PROPOSED IMMINGHAM EASTERN RO-RO TERMINAL

PINS REFERENCE TR030007

RESPONSE TO APPLICANT'S CHANGE REQUEST FROM DFDS SEAWAYS UK PLC

Document Information	
Project	Immingham Eastern Ro-Ro Terminal
Document title	Appendix 2 to Proposed Changes Notification Report - General Arrangement Plans
Commissioned by	Associated British Ports
Document ref	10.3.4
APFP Reg 2009	Regulation 5(2)(q)
Prepared by	ABP Project Team

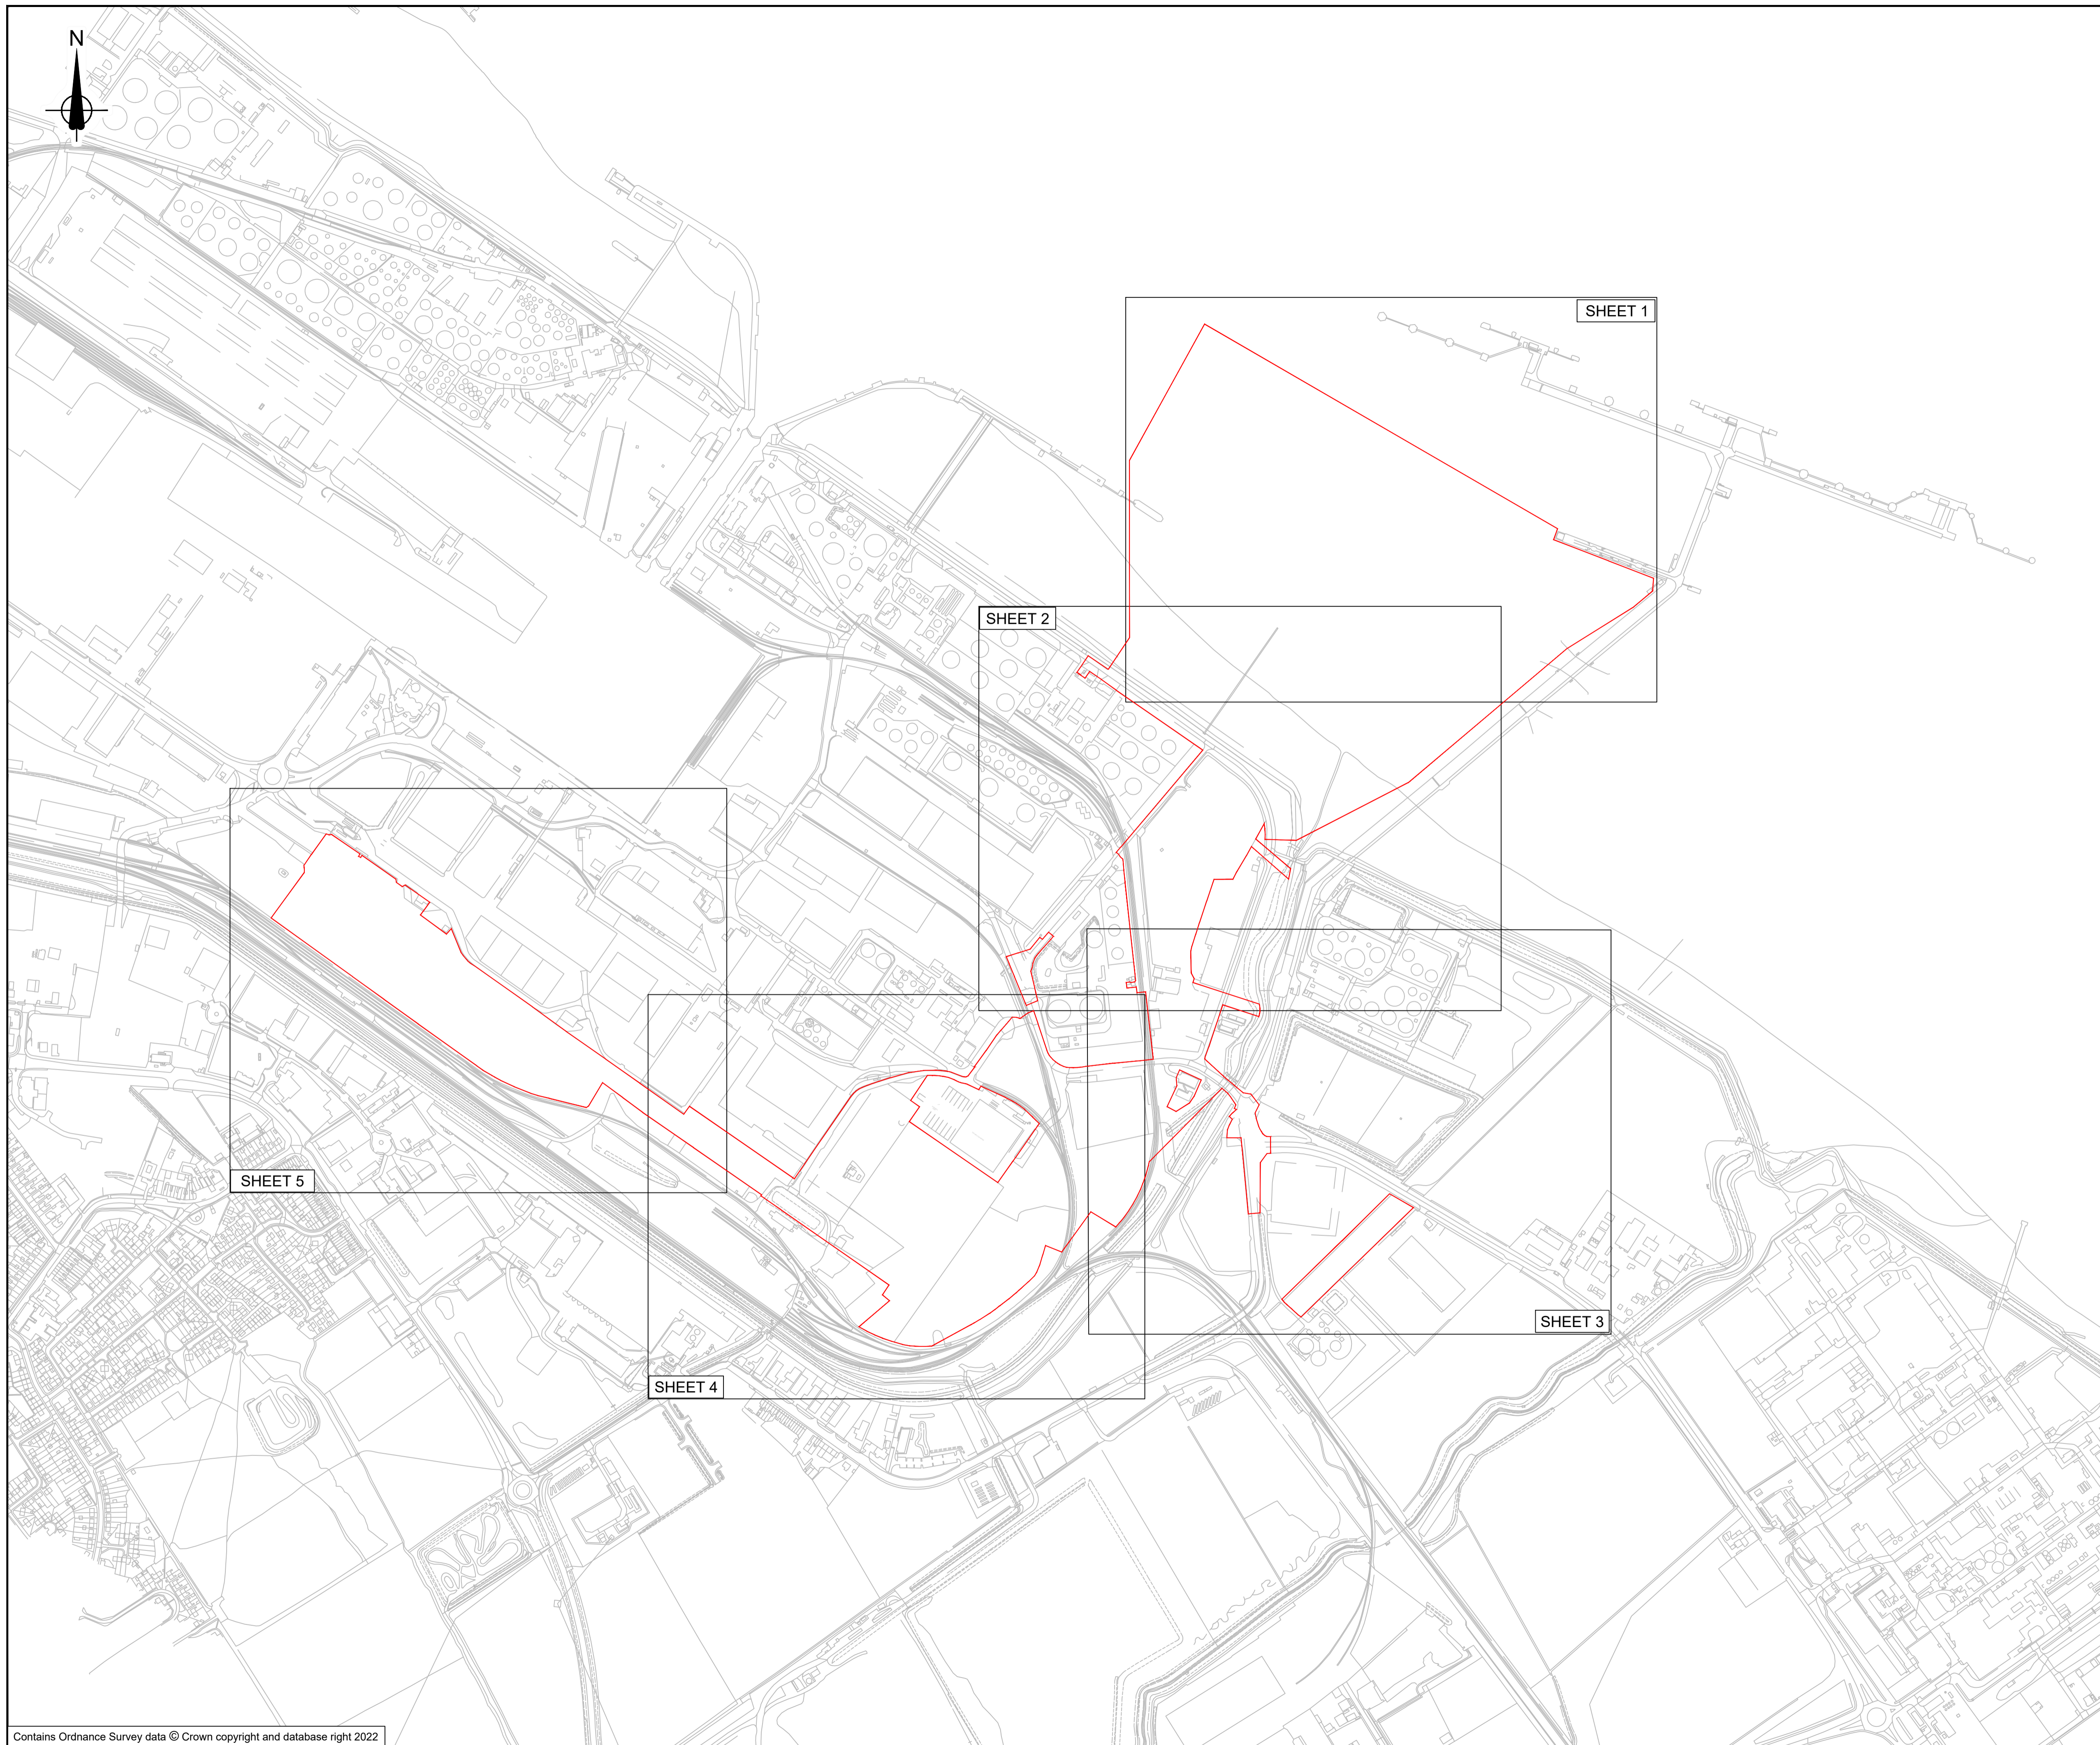
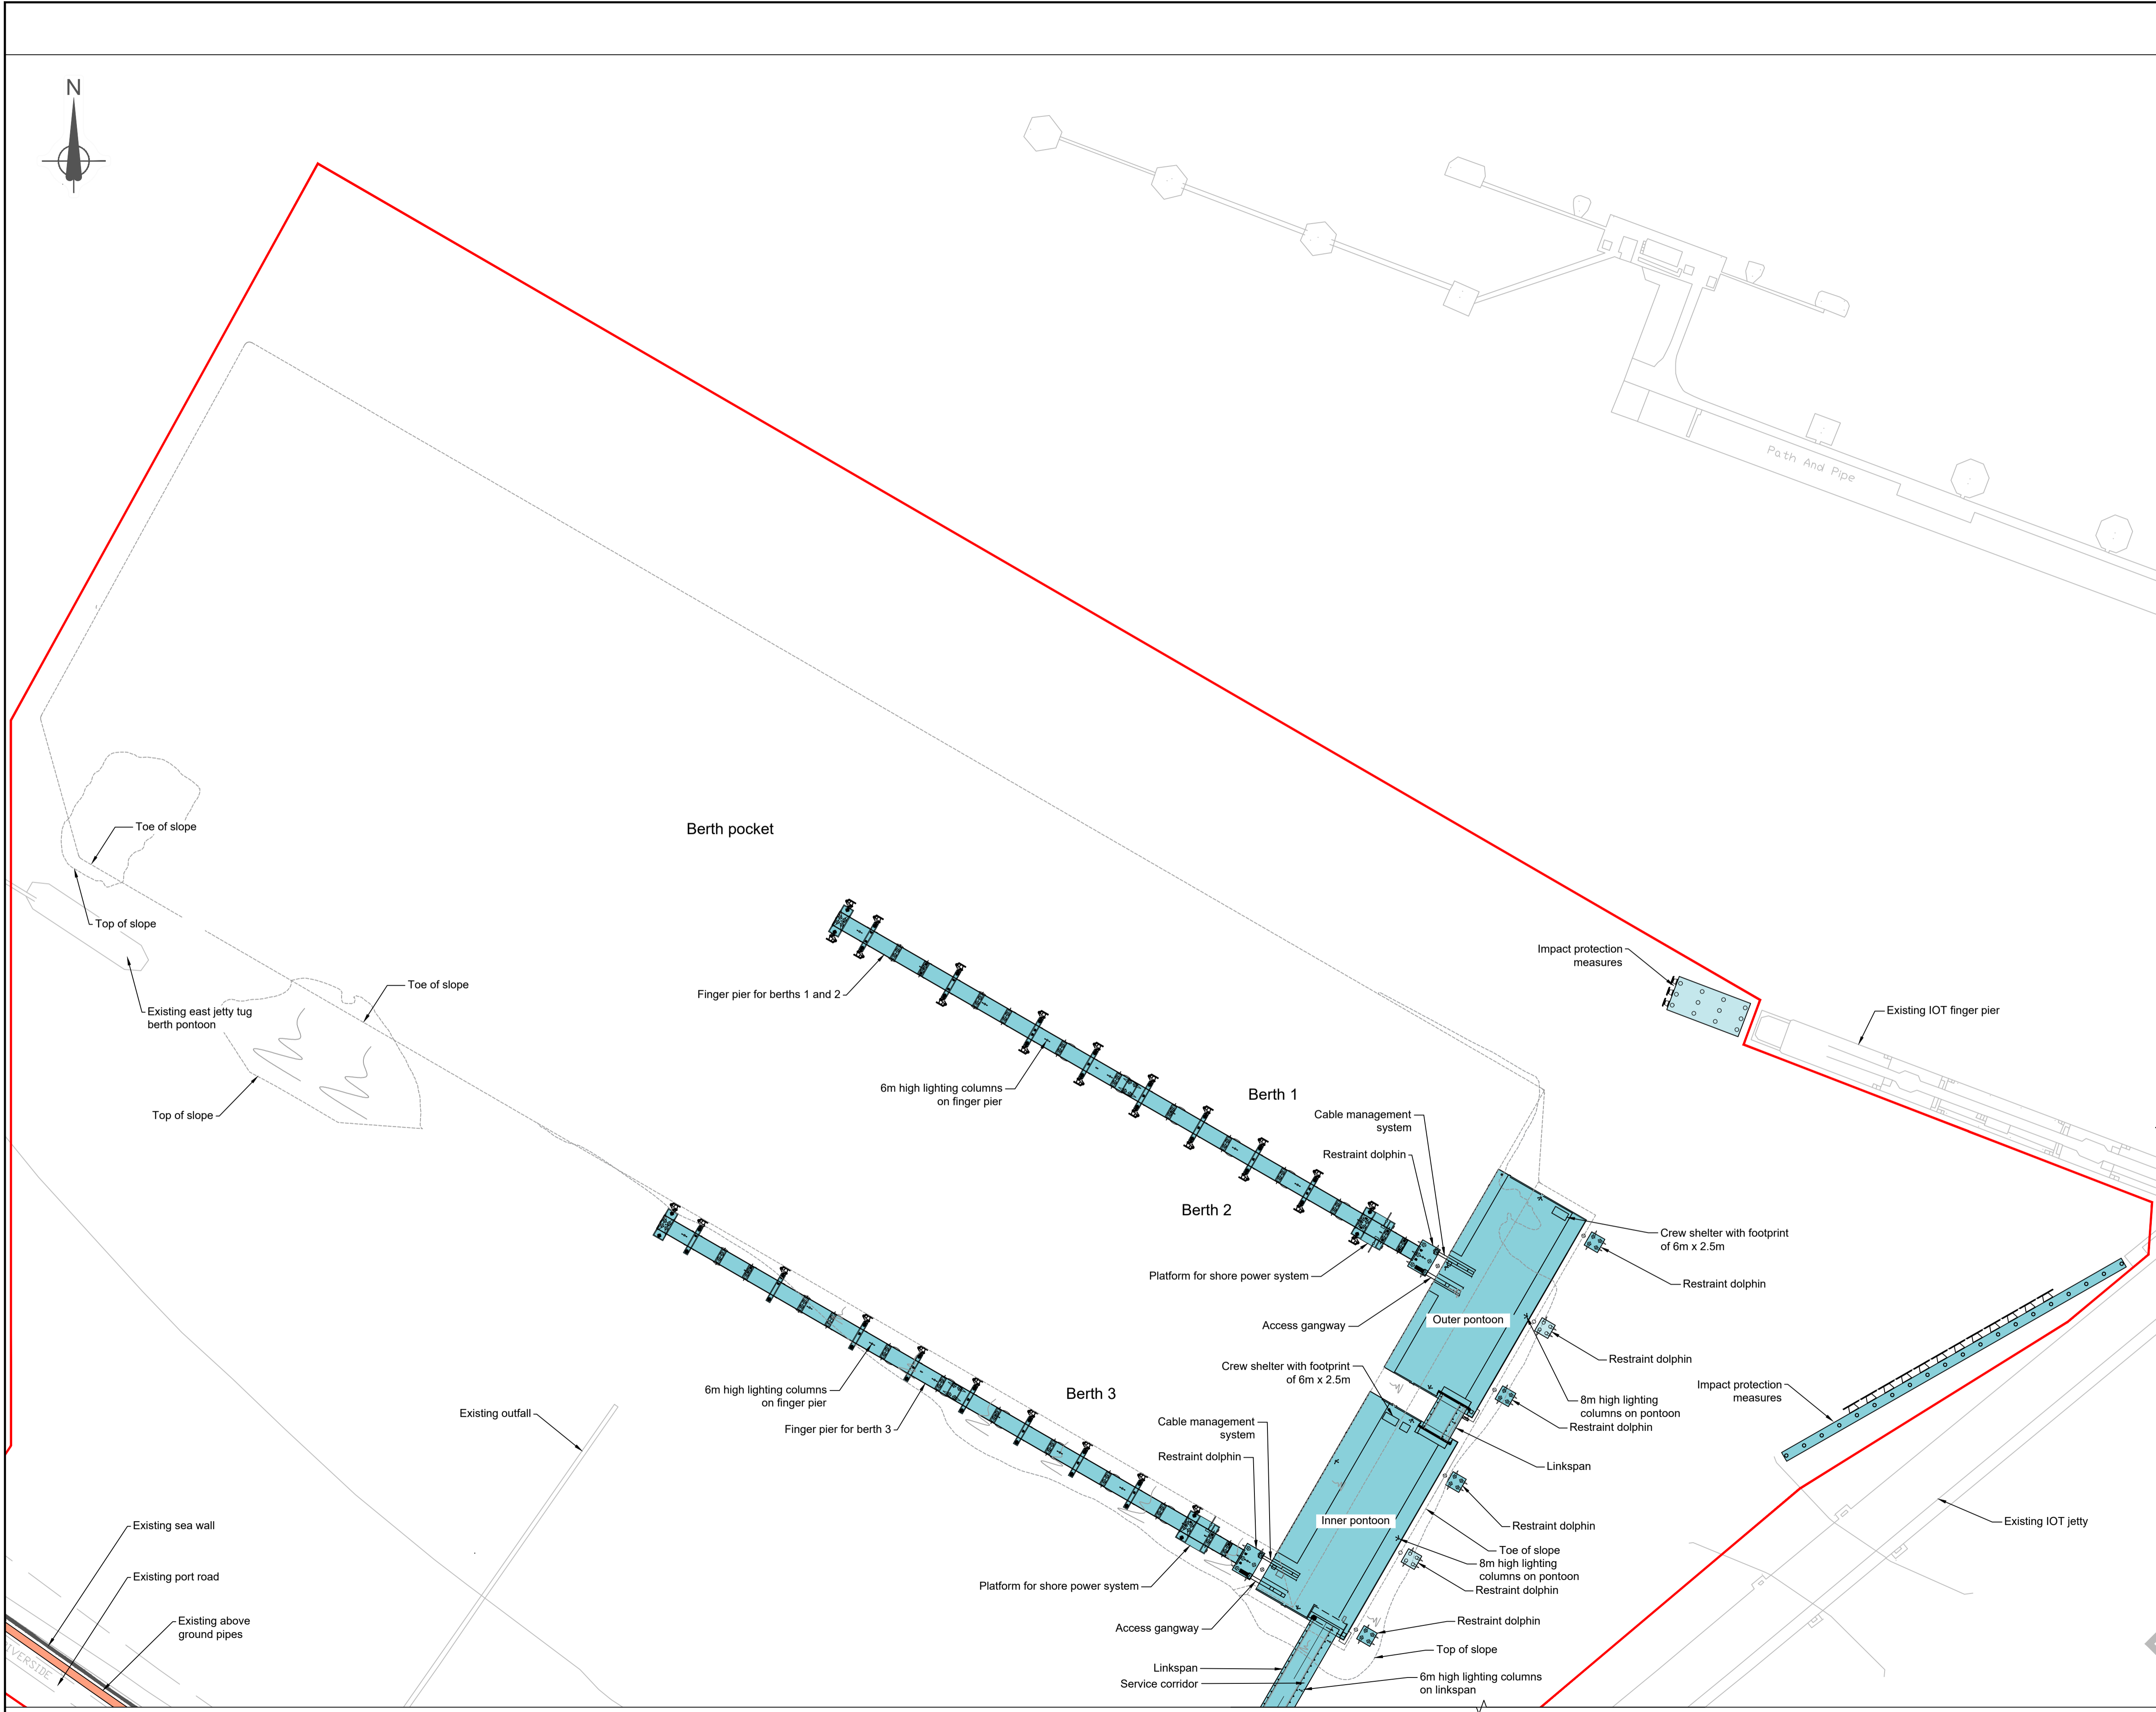
- 4.8 In the consultation version of the Environmental Statement Addendum it stated at paragraph 3.3.6 [AS-028] that there was to be a general increase in trailer spaces from 1,430 to 1,699. (3.3.6 of the ES Addendum) but no figure appears to be given in the 29 November version. The General Arrangement Plans [AS-029] and [AS-049] show the bays appear identical so presumably the total of 1,699 still stands.
